Airport Industrial Property Unit Trust ('AIPUT') hereby provides a brief Deadline 2 submission relating to the examination of the application made by Gatwick Airport Limited ('GAL') for a development consent order ('the DCO application') for the Gatwick Northern Runway Project ('the Project') under the Planning Act 2008 ('PA 2008').

REVIEW OF GATWICK AIRPORT LIMITED'S (GAL) DEADLINE 1 SUBMISSIONS

Surface Access Highways Plans – Structure Section Drawings – For Approval

Drawing file: TR020005 / TR020005-000813-4.8.3 Surface Access Highways Plans – Structure Section Drawings - For Approval.pdf

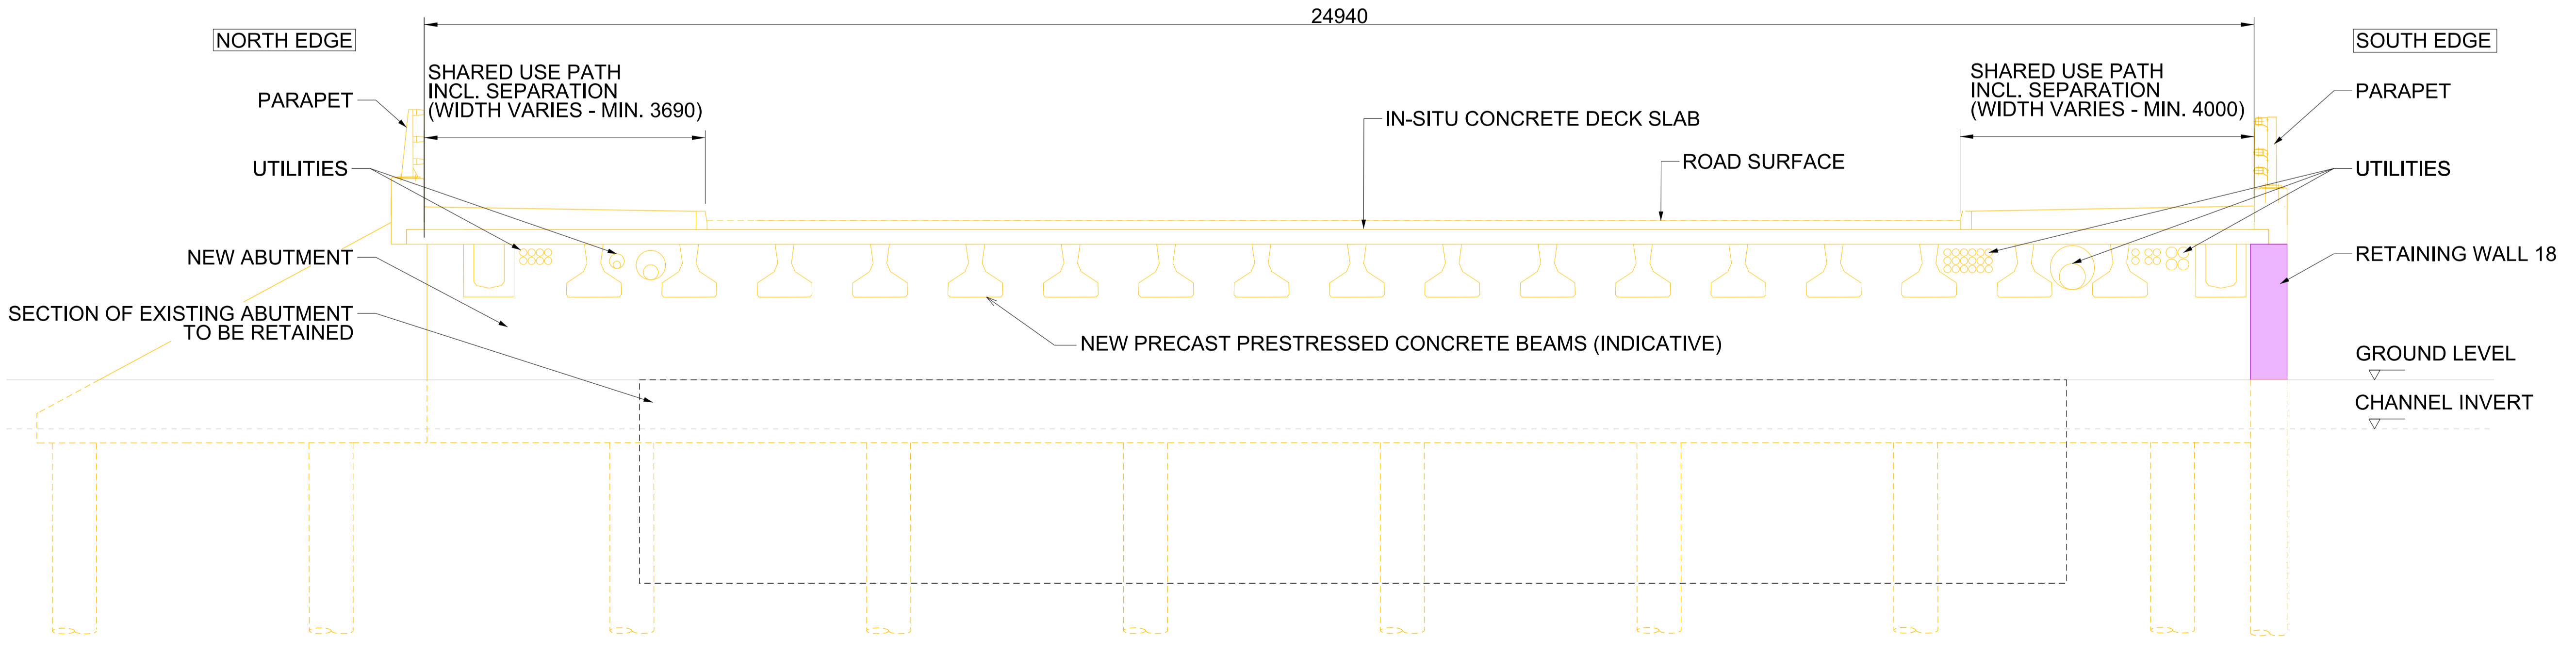
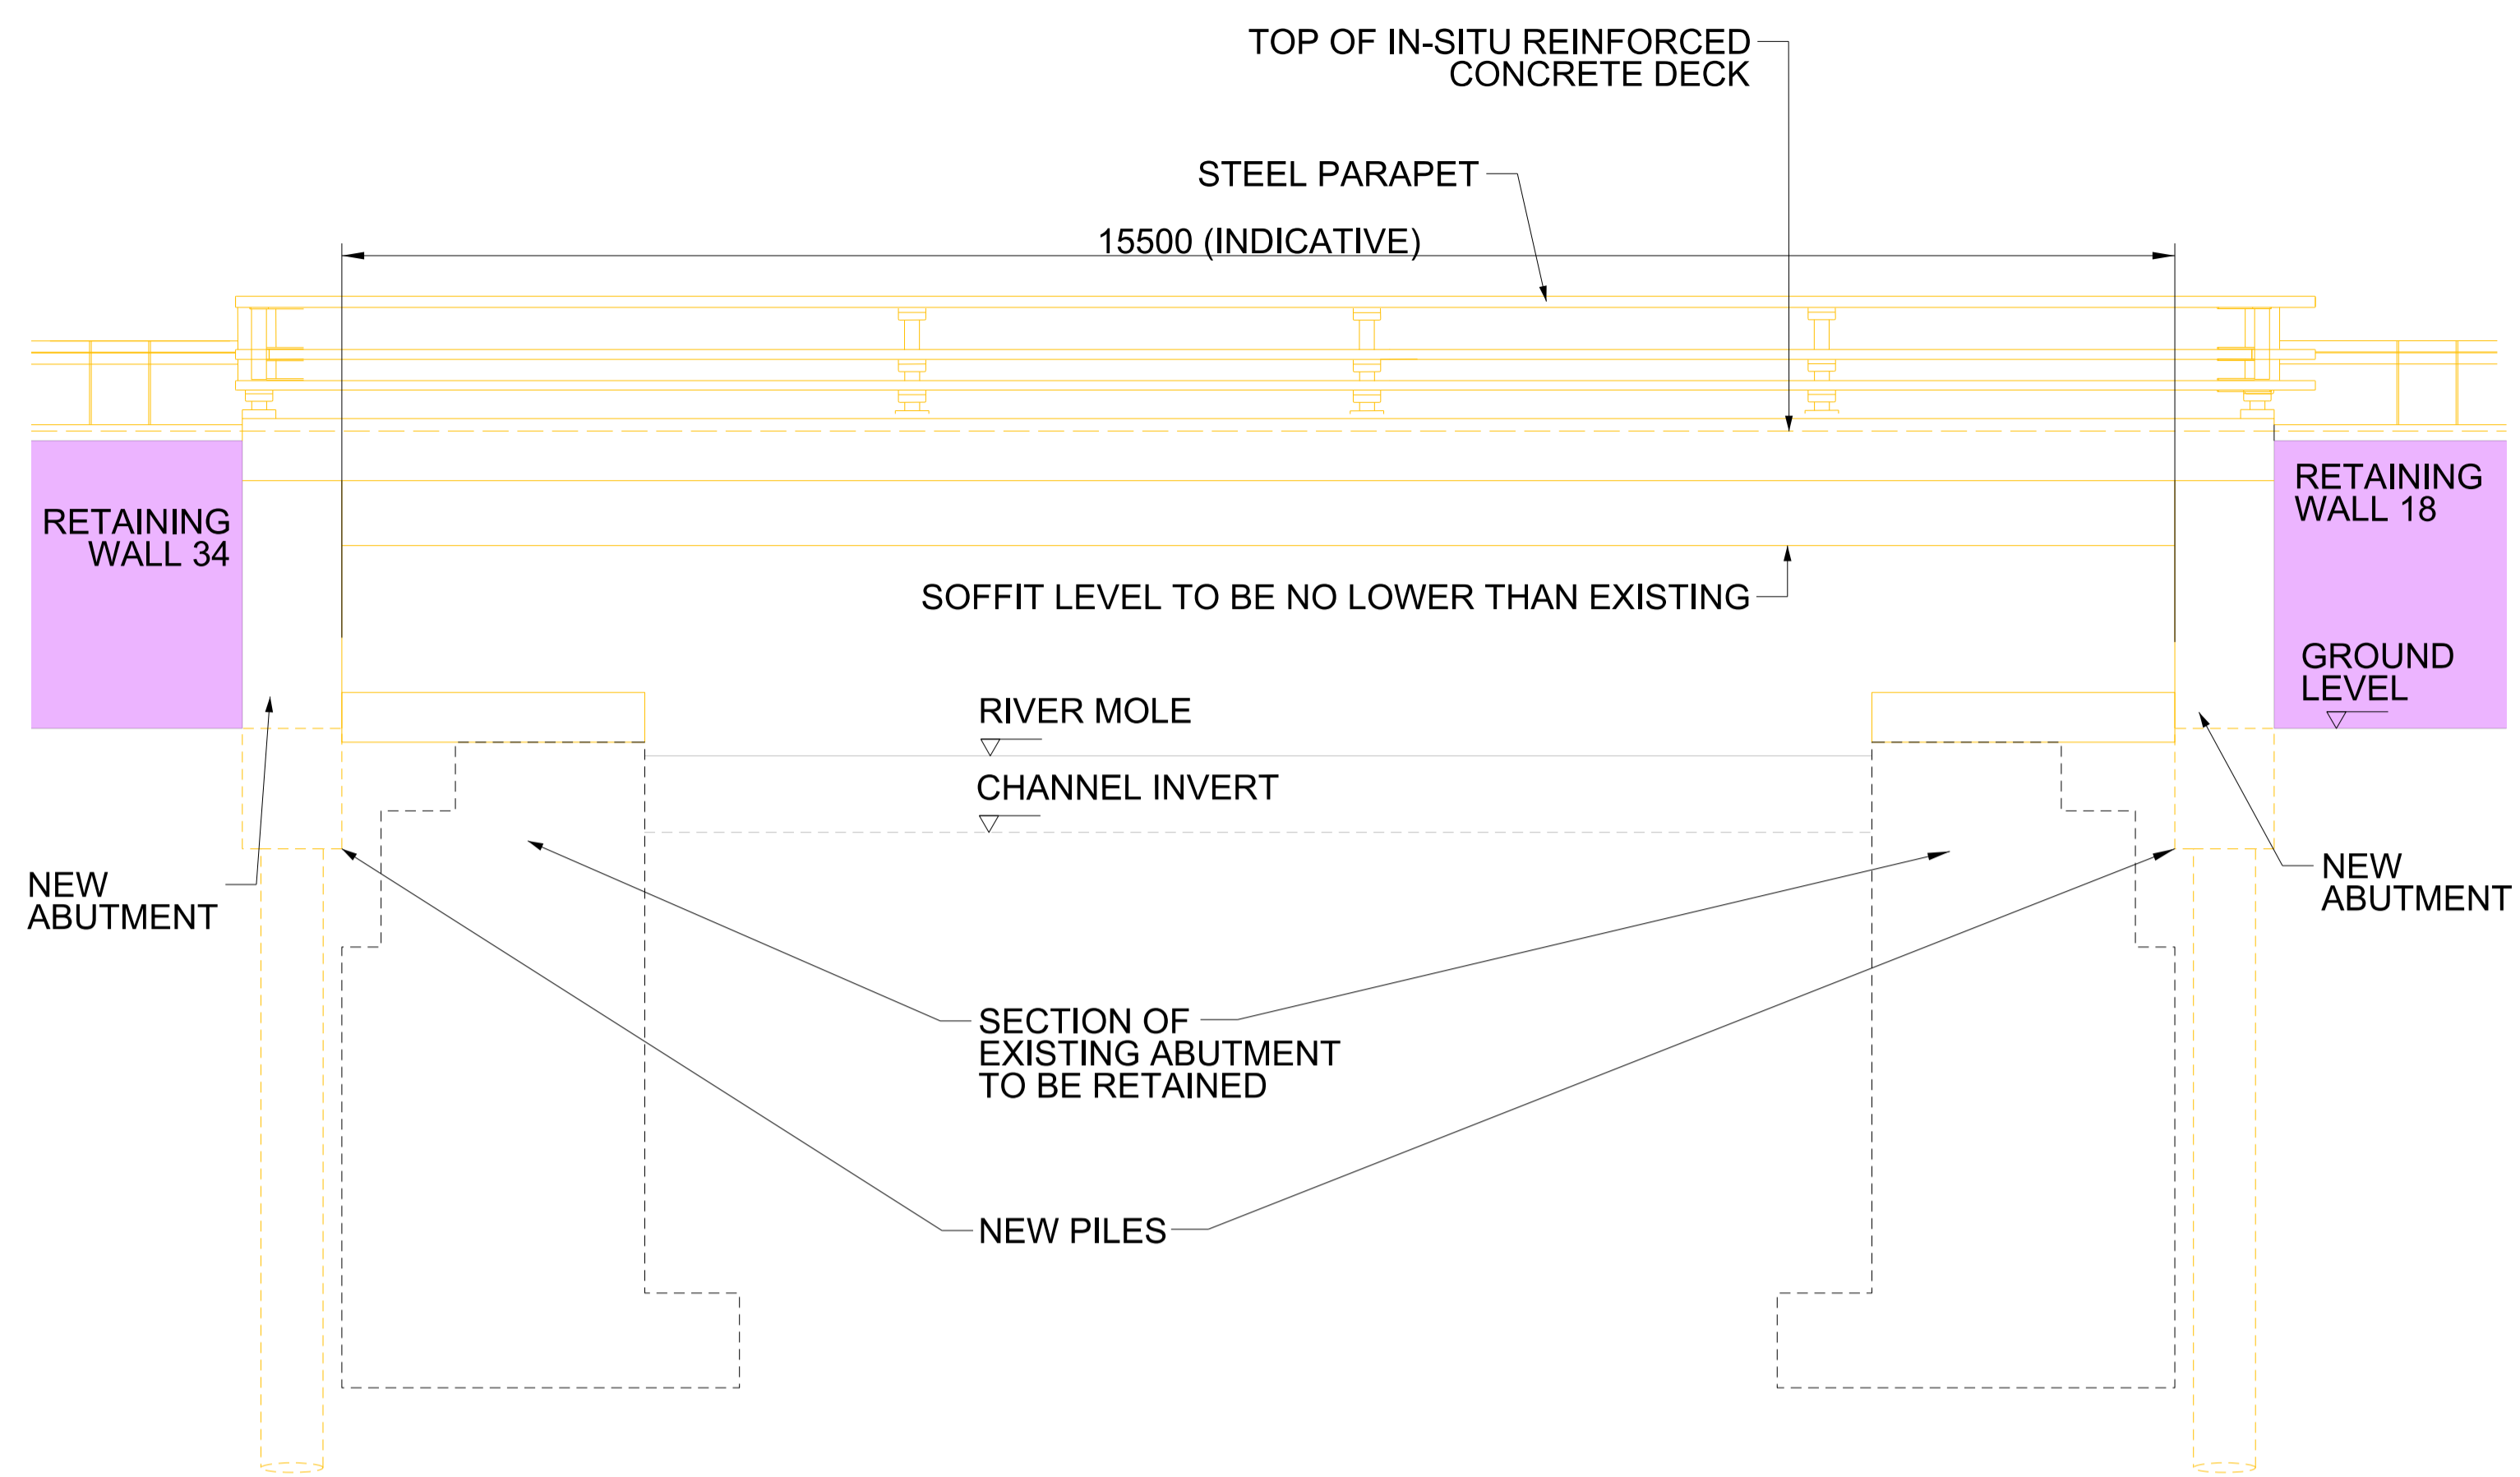
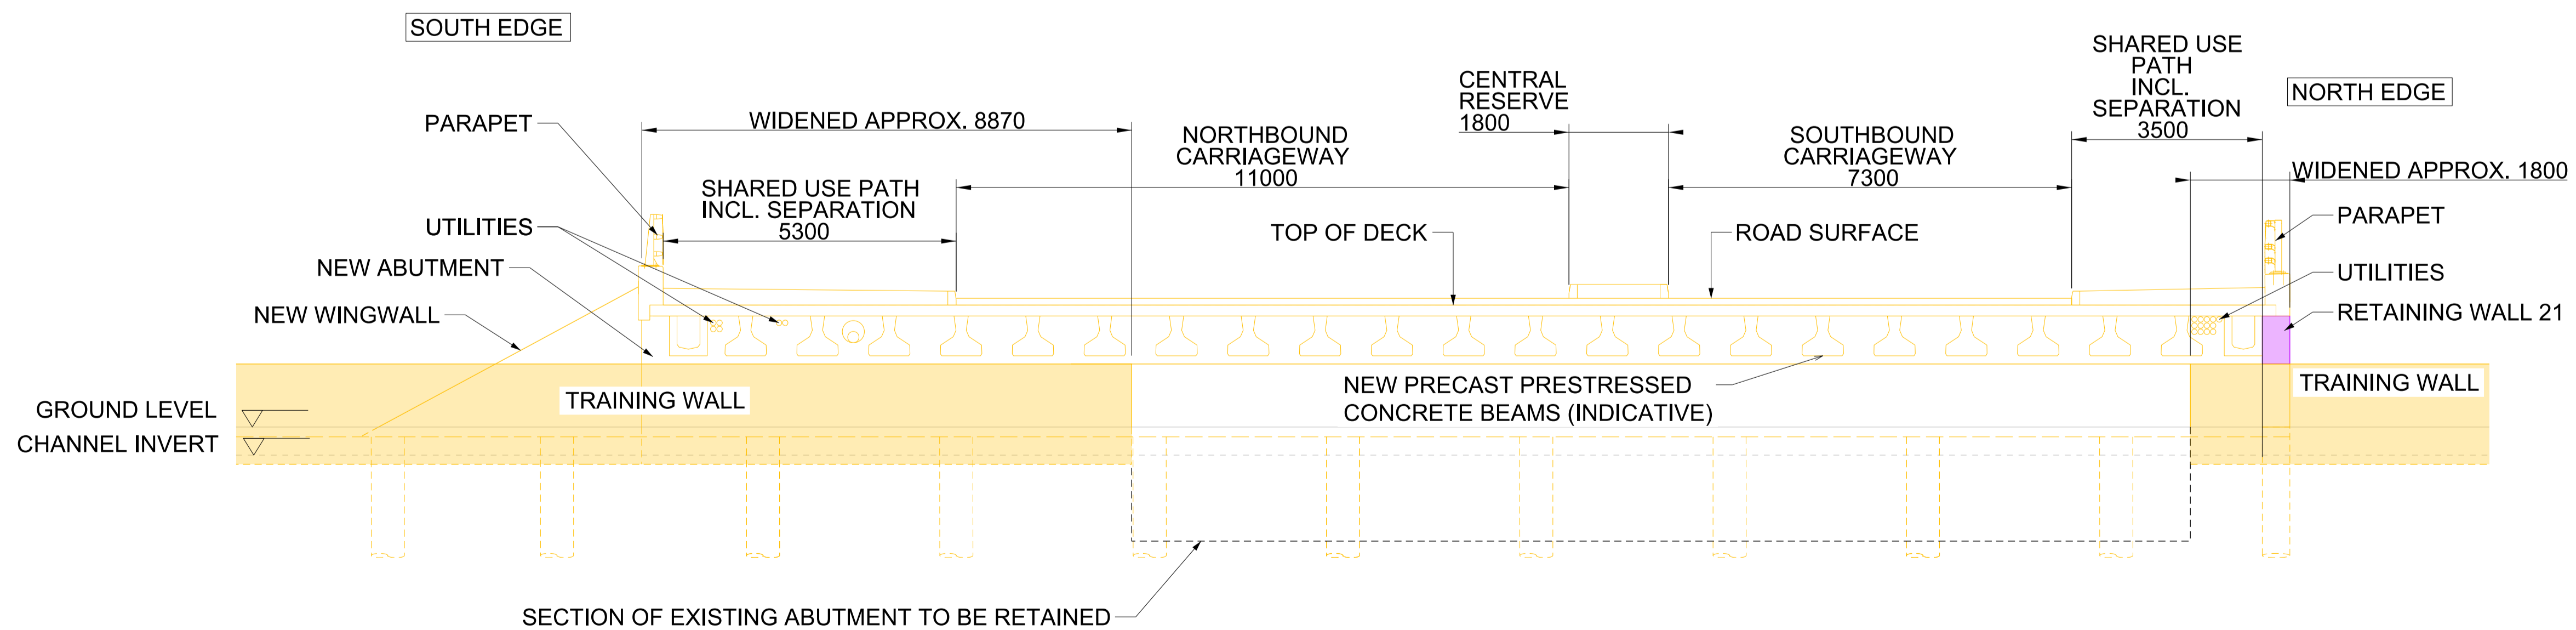
The structure section drawings are welcomed by AIPUT and provide some detail to the surface access highway plans being proposed. Motion would like to query on behalf of AIPUT, how the lane widths have been determined. For instance, the two-way single carriage ways are labelled as 7.25m despite a width of 7.3m being the established DMRB requirement, suggesting unfamiliarity with DMRB. AIPUT would also request that dimensioned plans are provided for junctions across the highway network.
